app v_1 redlines EXHIBIT B.pdf Markup Summary 12-22-2020

**WSE-O PLAN AMENDMENT (WSEO-20-1)**  
EL PASO COUNTY, COLORADO  
FRONT RANGE-MIDWAY SOLAR PROJECT  
PROPOSED SOLAR GENERATION MAP

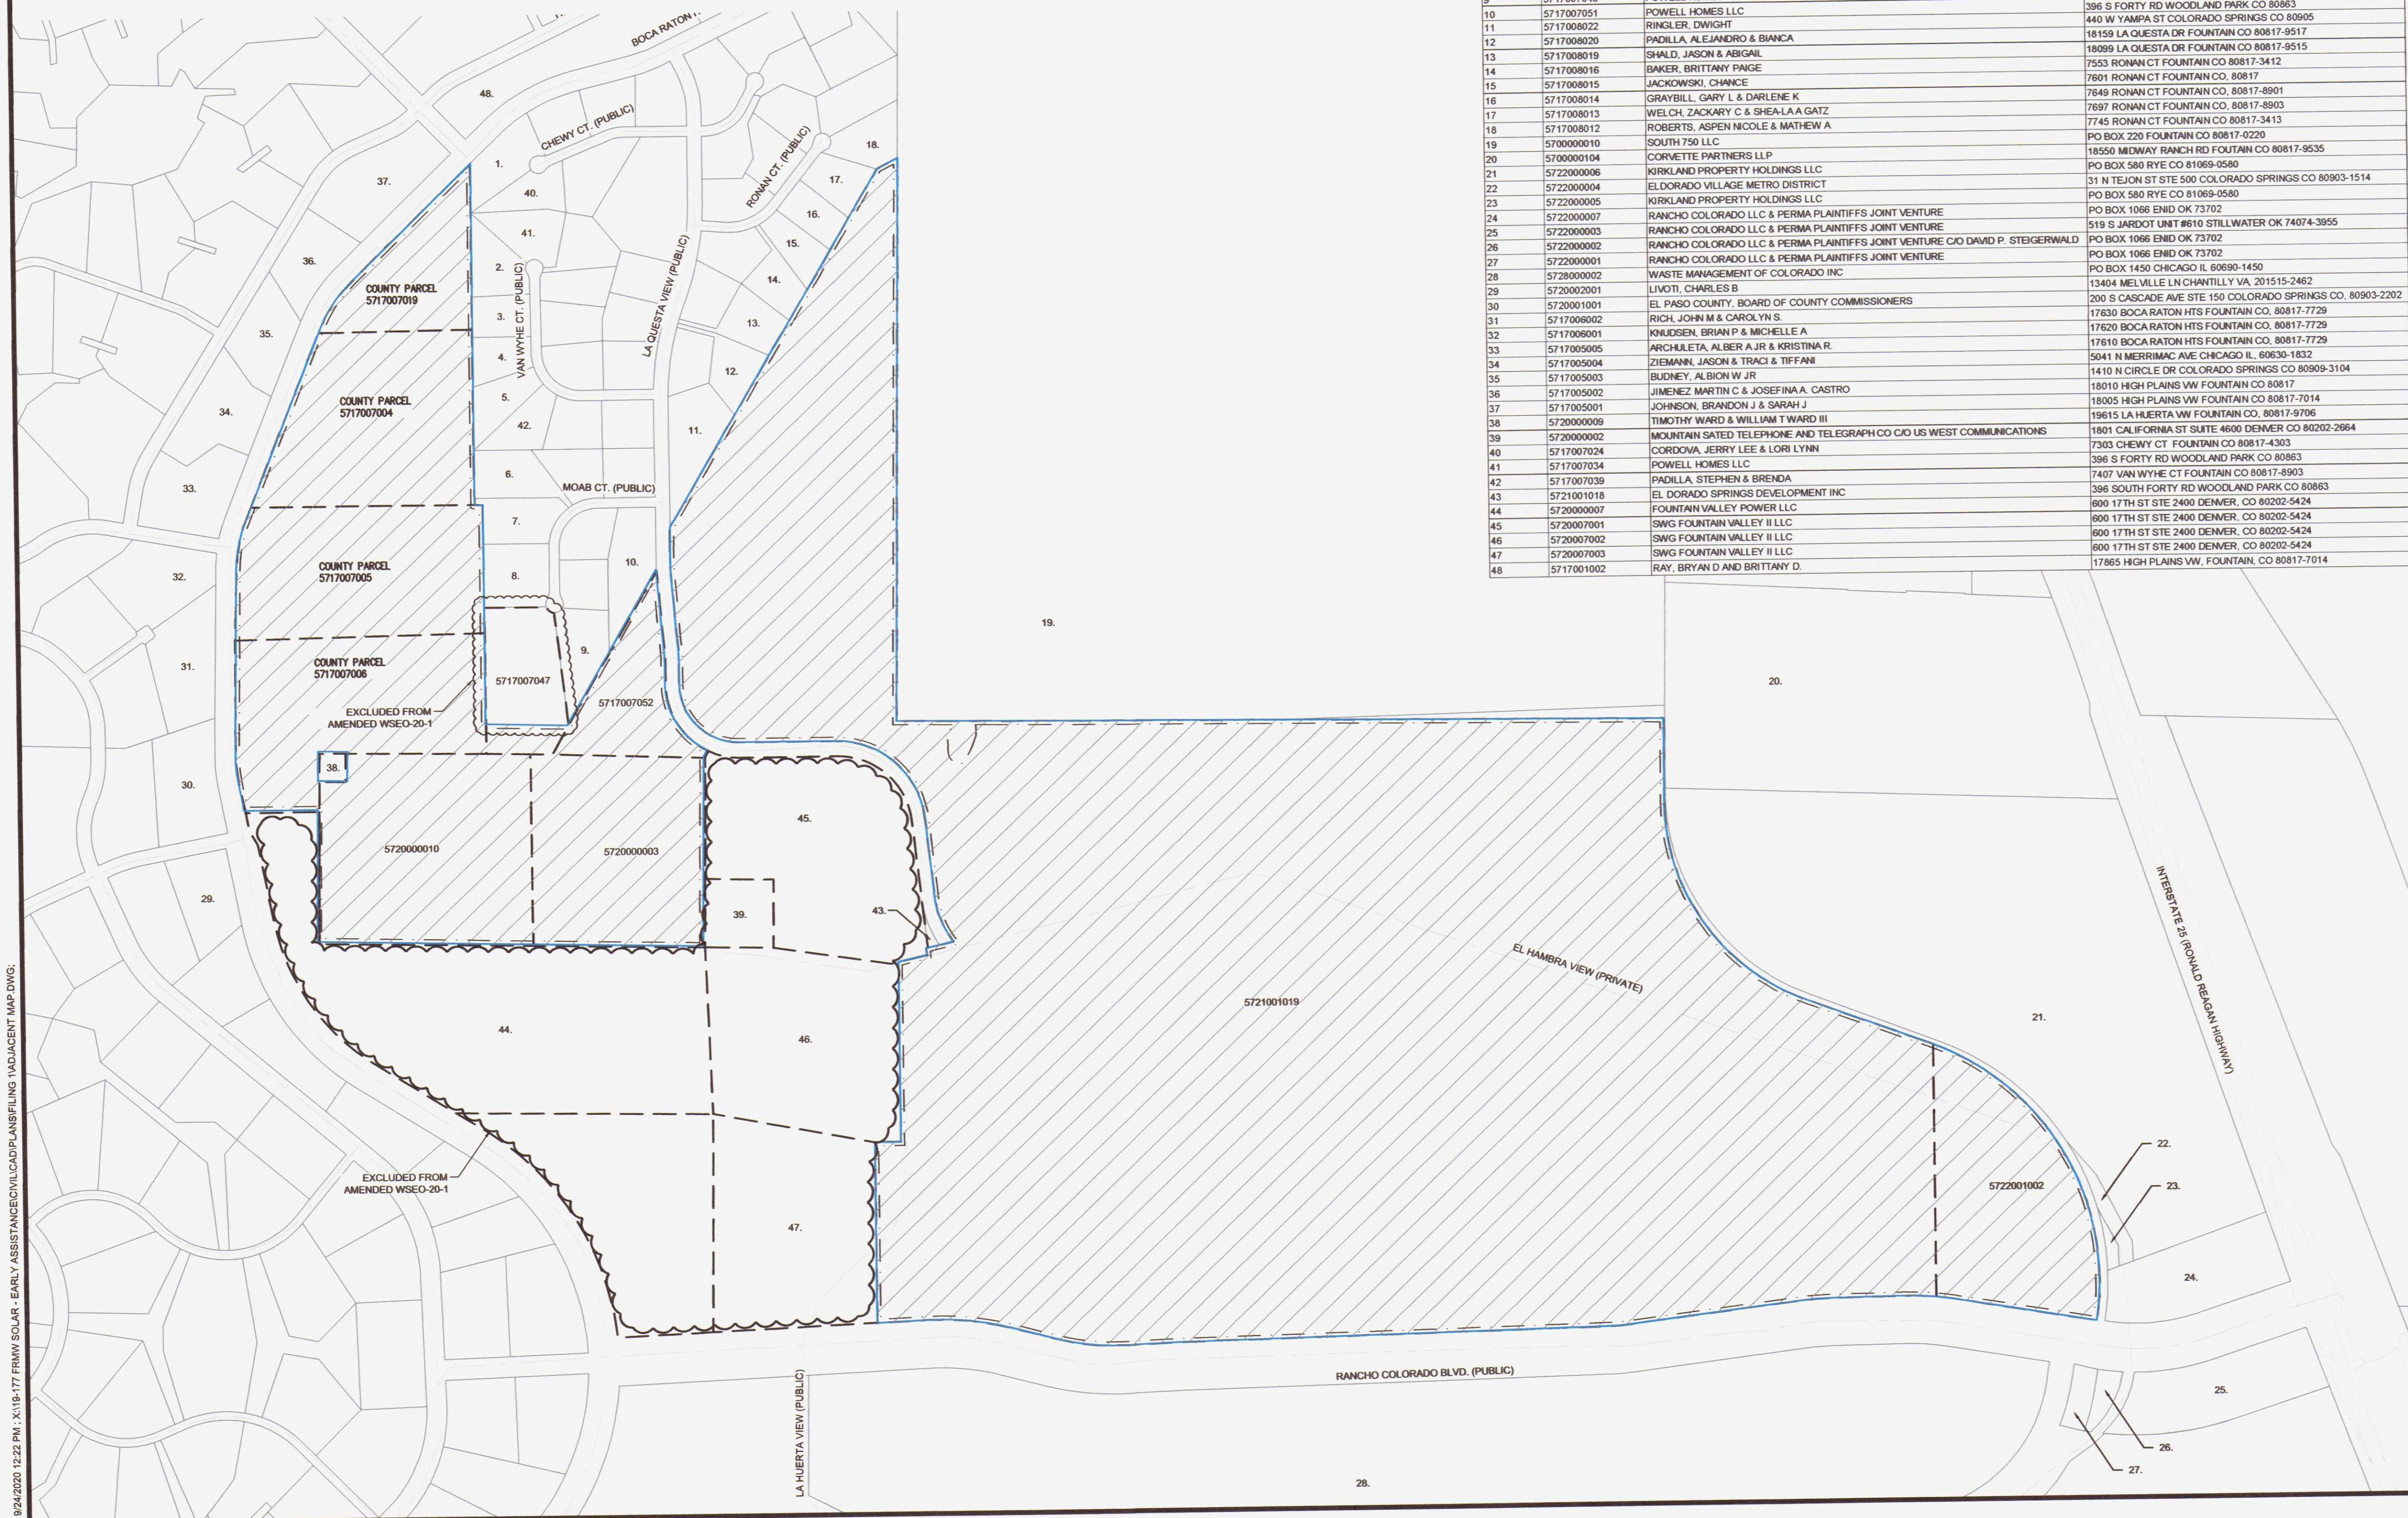
OUT OF DATE WSEO map; USE THE 2020

**WSEO-20-1 PLAN AMENDMENT (WSEO-20-1)**  
EL PASO COUNTY, COLORADO  
FRONT RANGE-MIDWAY SOLAR PROJECT  
ADJACENT PARCEL OVERLAY MAP

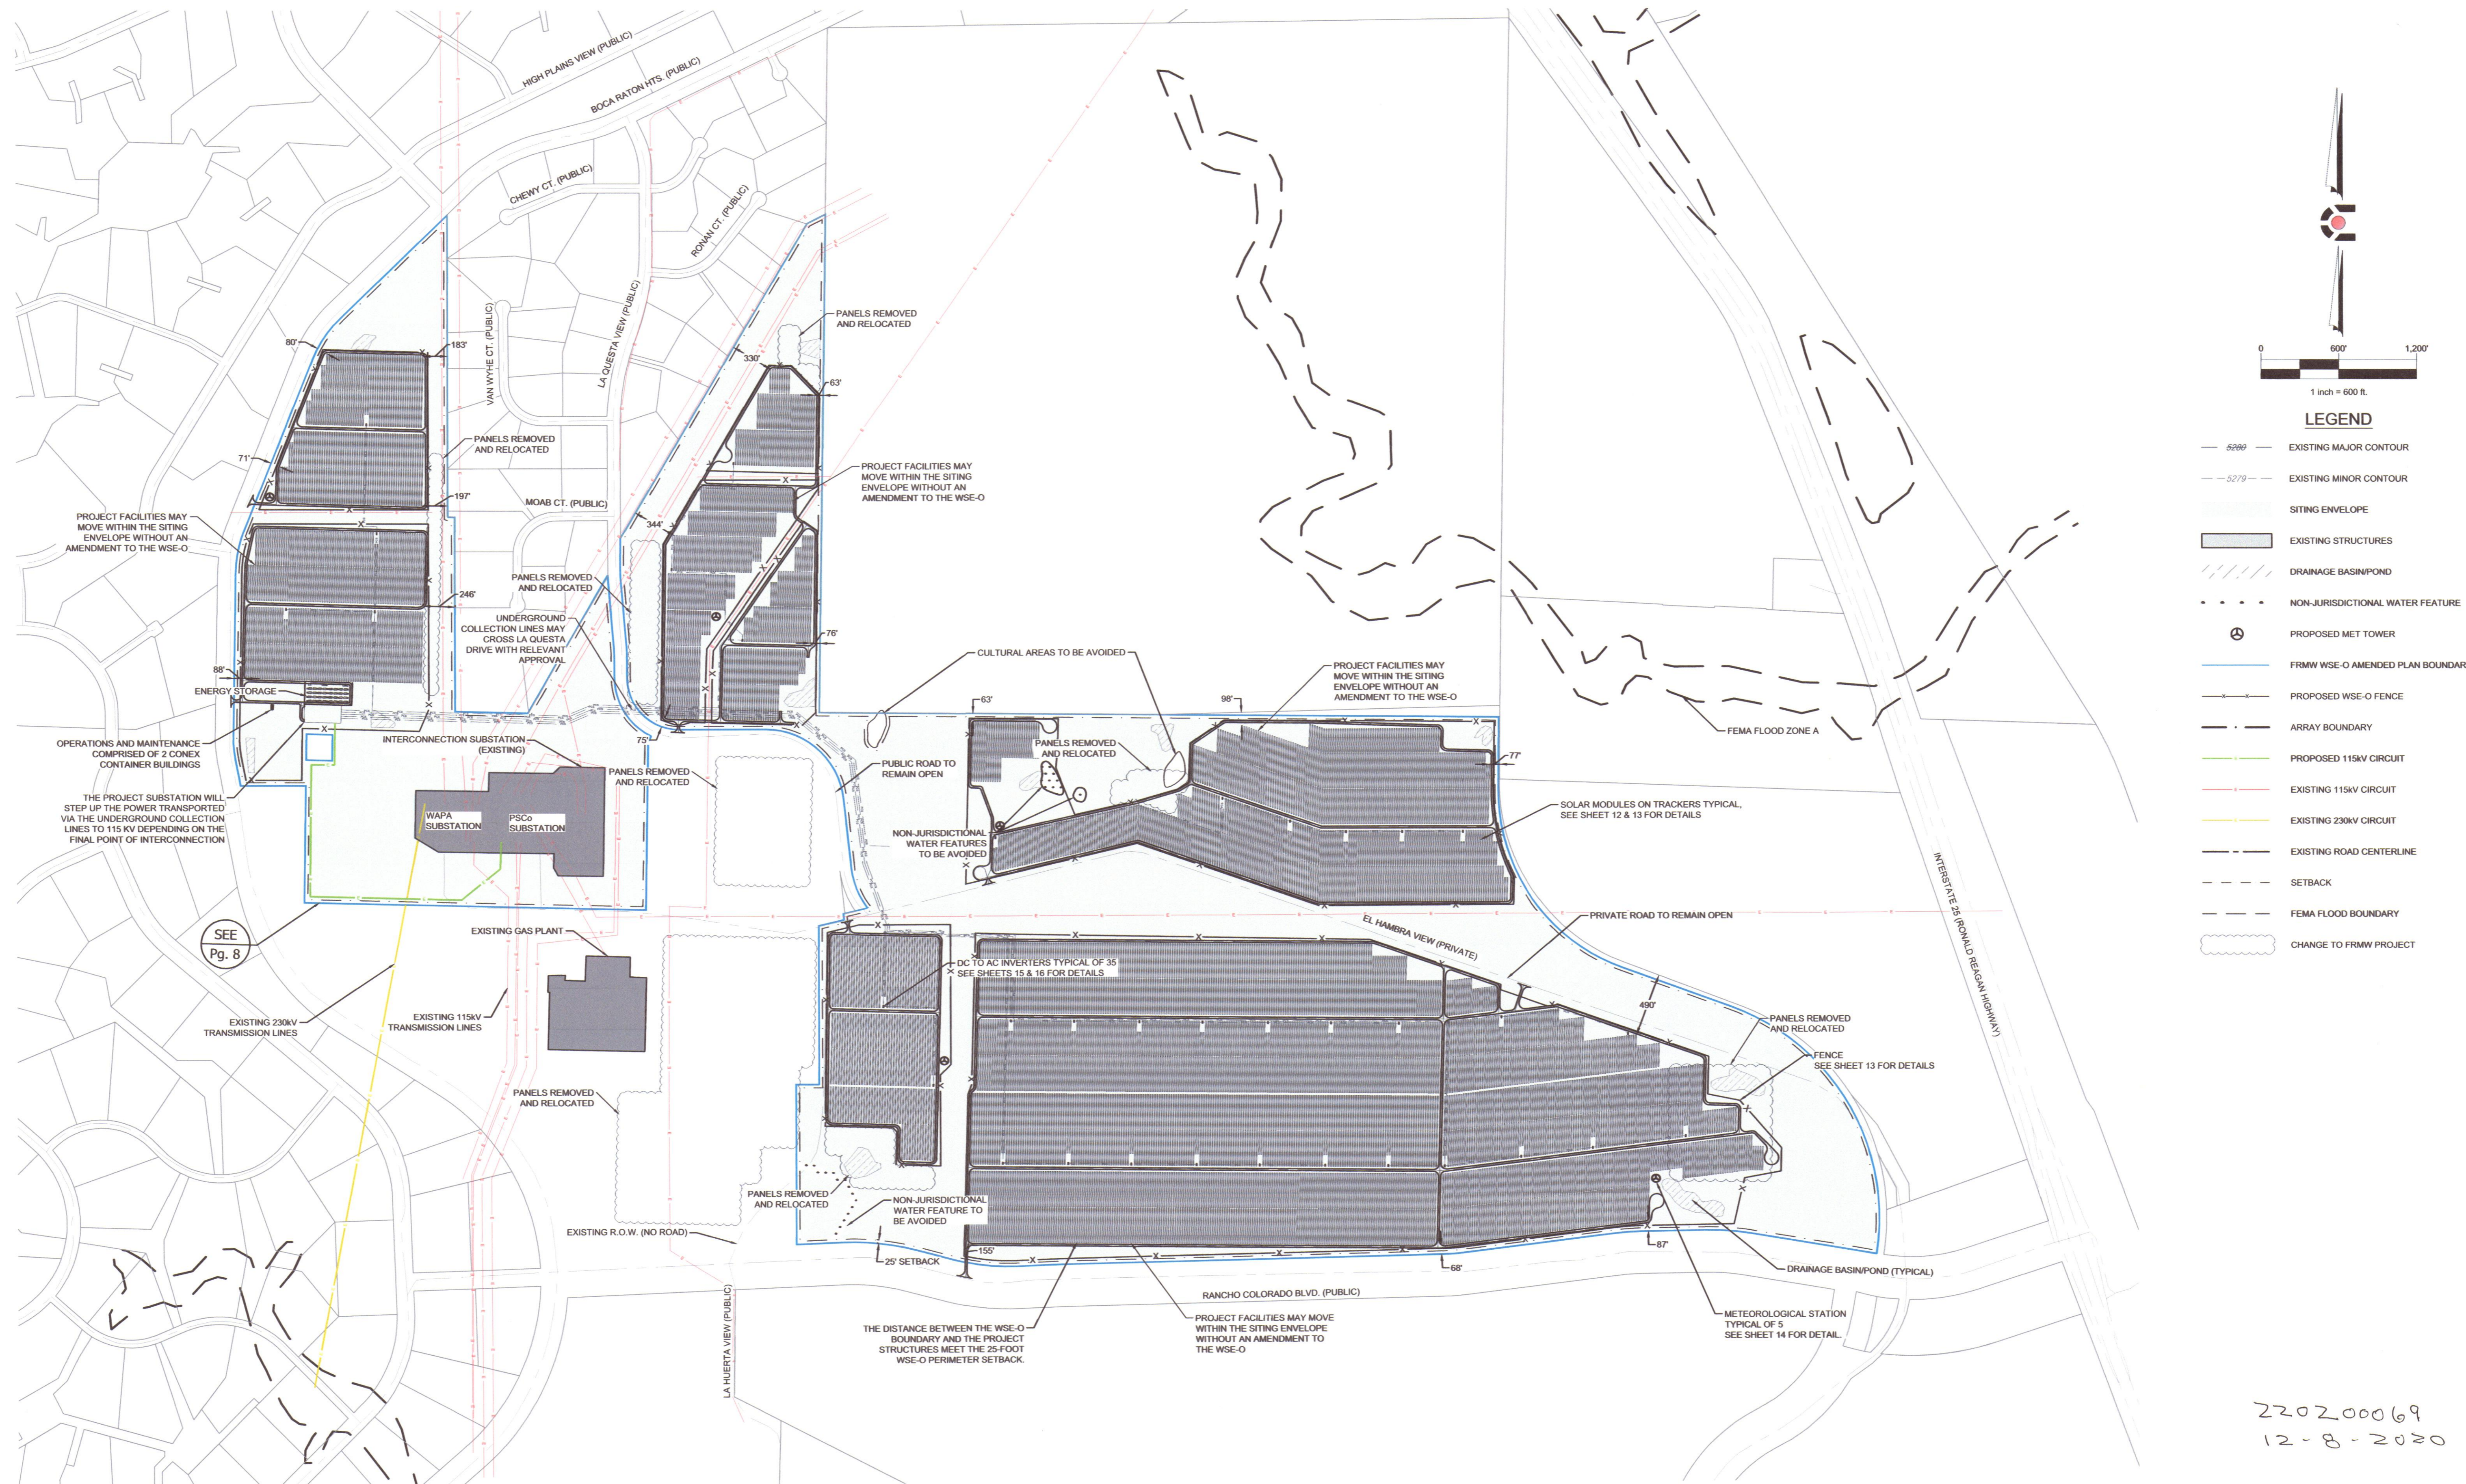
this is missing some parcels that were include in the WSEO....There are more than 1.
